A303 Sparkford to Ilchester Dualling Scheme TR010036

8.1 Statement of Common Ground with Environment Agency

STATEMENT OF COMMON GROUND

**PROPOSED DUALLING SCHEME A303 SPARKFORD TO ILCHESTER -
SUBMISSION OF WFD SCREENING AND SCOPING ASSESSMENT
HAWRAT ASSESSMENT AND FLOOD RISK ASSESSMENT (FRA)**

Location

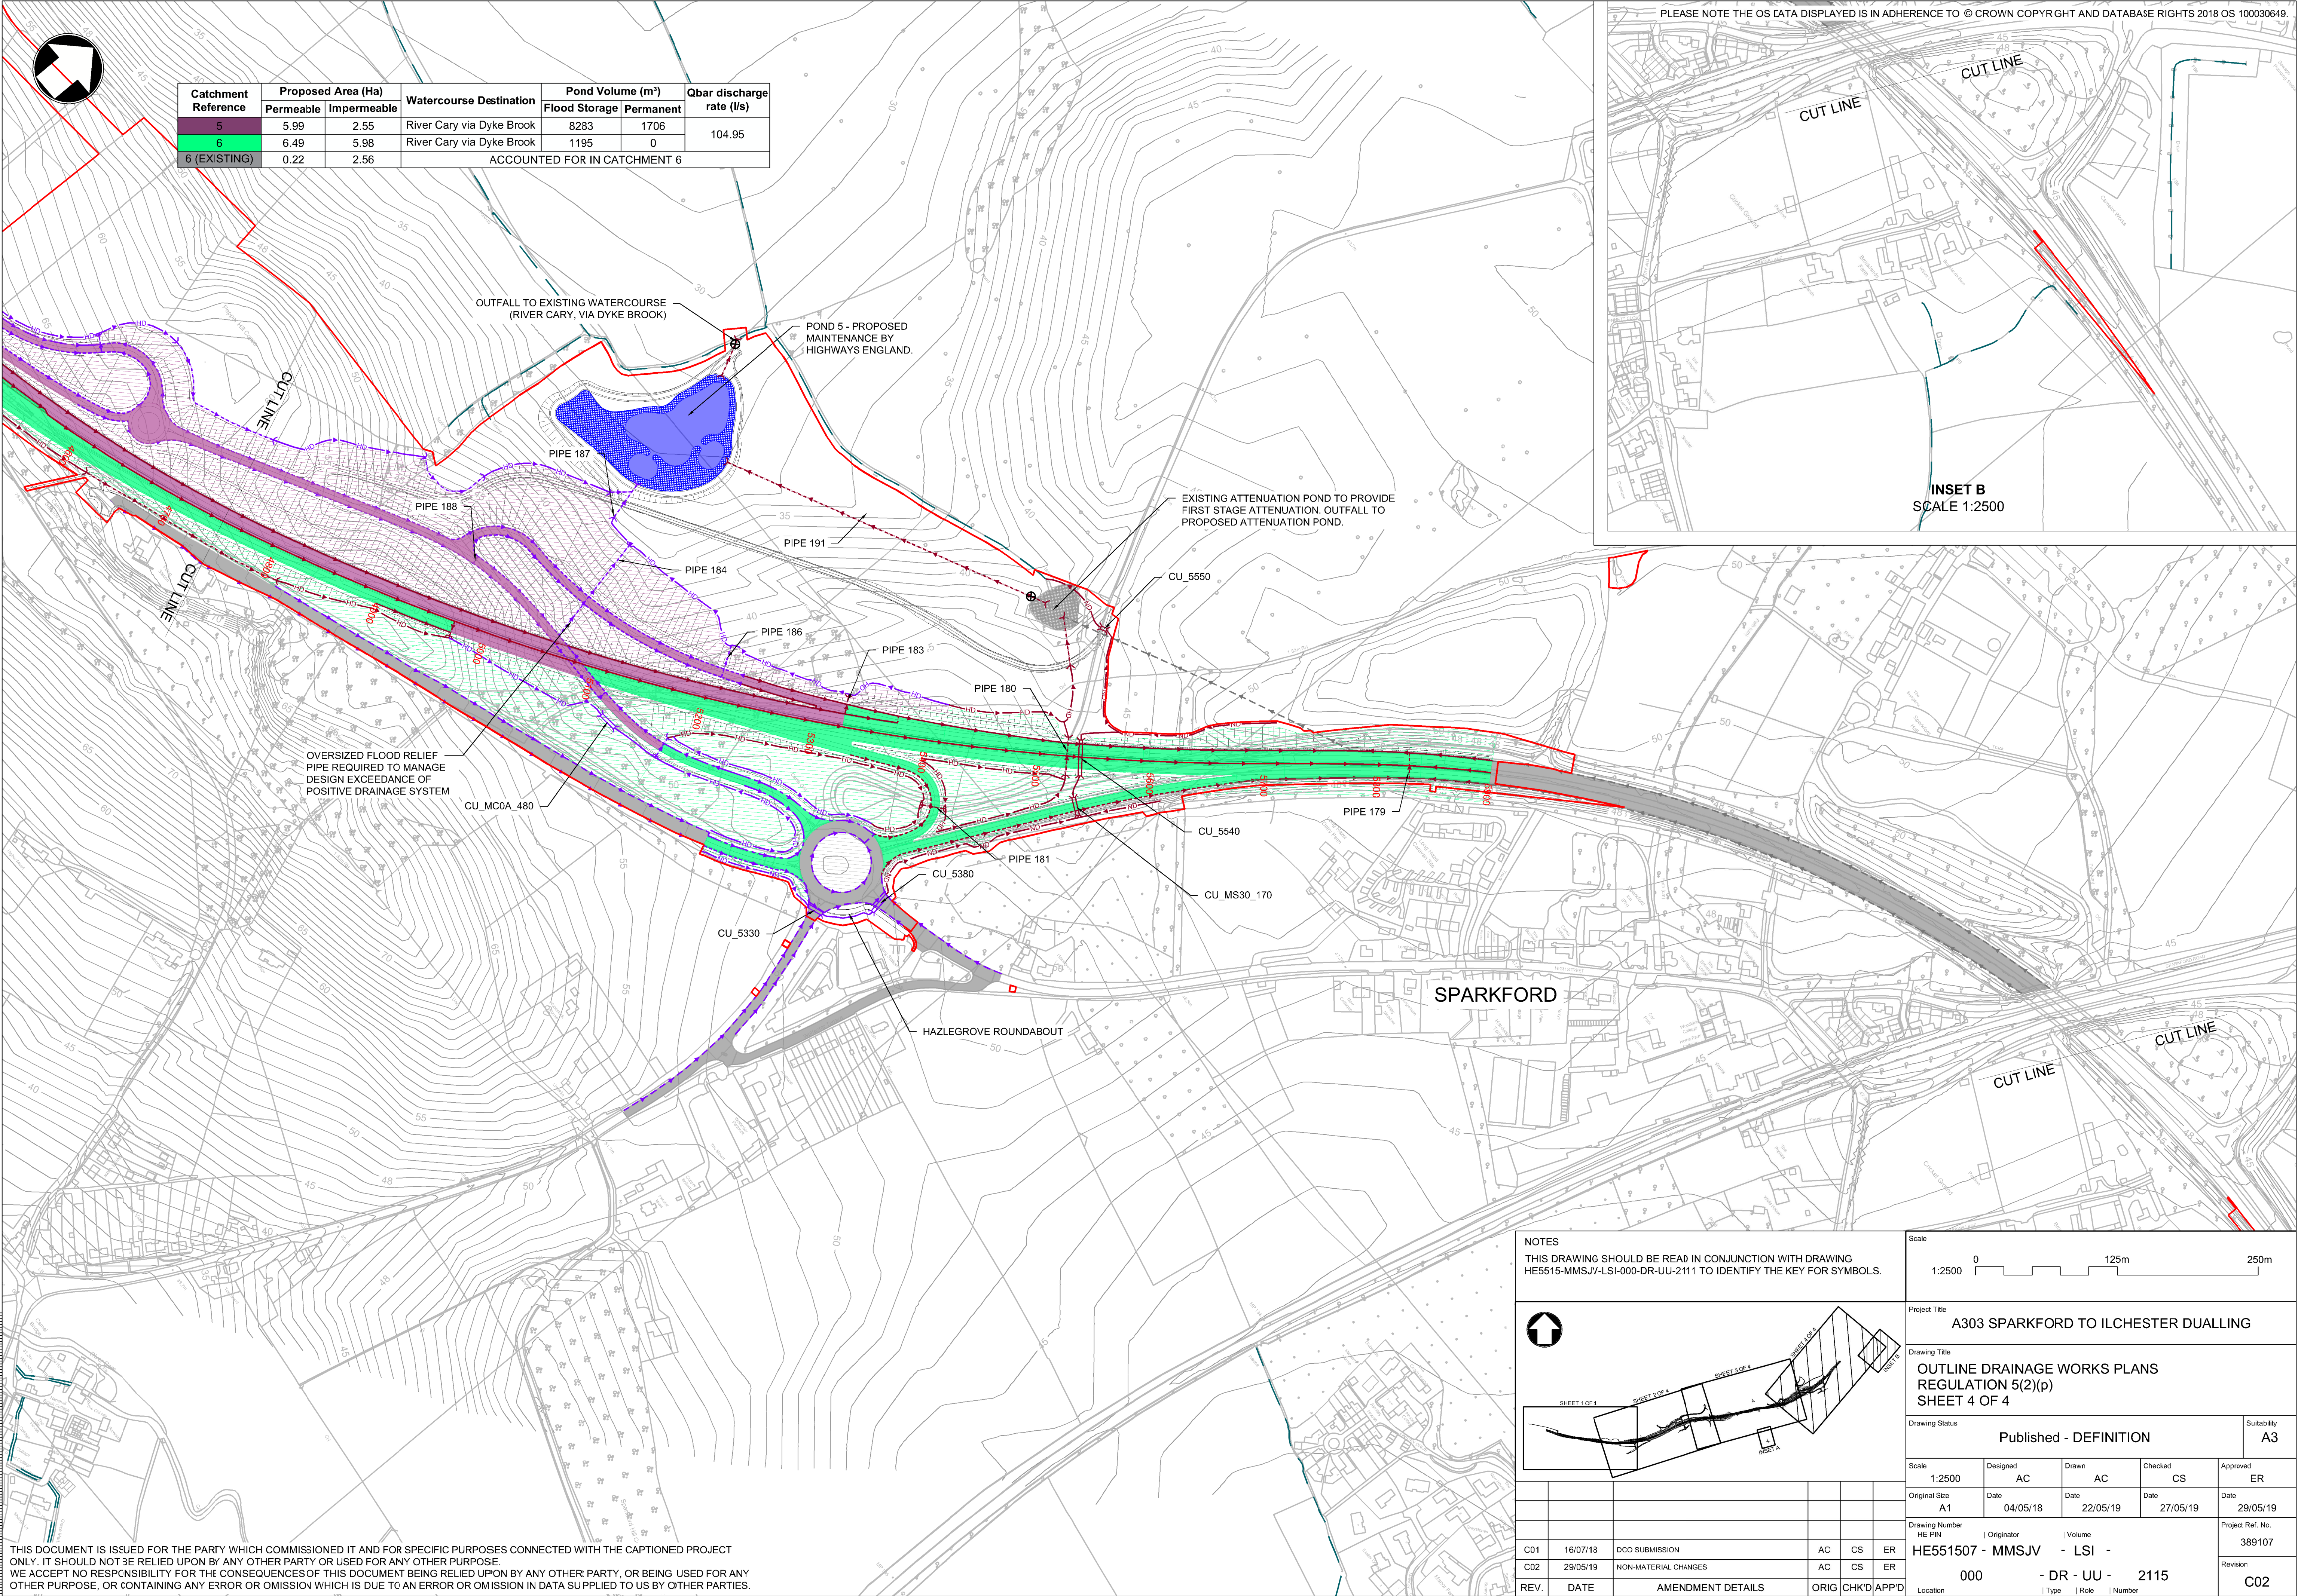
Topic	Sub-section	Environment Agency comment	Highways England response	Status
	Assessment Methodology.		<p>concluded the scheme would have negligible impacts on the water environment (with potential for some benefits / opportunities). Further detailed assessment of the RDWE as part of the Environmental Statement would likely conclude the same negligible effects, and therefore in the interests of proportionate EIA, we believe that the 3 detailed assessments and a supporting RDWE technical appendix which sign posts to these documents is sufficient.</p> <p>It should be noted that potential groundwater effects associated with contaminated land are covered within Chapter 9 Geology and Soils of Volume 6.1 of the ES.</p>	(Appendix A)
Water quantity	Not applicable	<p>It is recommended that the effects of climate change are accounted for in the Flood Risk Assessment (FRA) and drainage strategy. This should include details of surface water attenuation features designed to control runoff to the receiving watercourses.</p>	<p>Accepted.</p> <p>The rainfall intensities used to calculate the design storms include an allowance for the effects of climate change by allowing for the upper bound 40% increase (Flood risk assessments: climate change allowances, Environment Agency).</p> <p>Evidenced in Flood Risk Assessment (Appendix 4.6 of TR010036/APP/6.3) and Drainage Strategy Report (Appendix 4.7 of TR010036/APP/6.3).</p> <p>Attenuation feature discharge rates and volumes shown in Outline Drainage Works Plans (TR010036/APP/2.11).</p>	AGREED (Appendix A)

Topic	Sub-section	Environment Agency comment	Highways England response	Status
		Confirmation is sought that the proposed design will control the overall volume, as well as the overall rate of runoff with sufficient attenuation provided.	Attenuation has been provided, with discharge limited to 1% annual exceedance probability (1 in 100-year event) plus 40% to account for the effects of climate change (Flood risk assessments: climate change allowances, Environment Agency), to no greater than the undeveloped rate of runoff, determined by the calculation of the mean annual peak rate of runoff for a greenfield site (Qbar). Preliminary design discharge rates and volumes shown in Outline Drainage Works Plans (document reference TR010036/APP/2.11).	AGREED (Appendix A)
		With reference to flood risk management issues, the documentation does not include the Agency's confirmation that the proposed route is located outside designated flood zones 2 and 3 and is therefore not liable to any significant main river fluvial or tidal risks. The highlighted risks are from surface water and or IDB/ordinary watercourses.	The Flood Risk Assessment considers all sources of flood risk, including but not limited to the fluvial and tidal flood zones, ordinary watercourse and surface water runoff. Evidenced in Flood Risk Assessment (Appendix 4.6 of TR010036/APP/6.3).
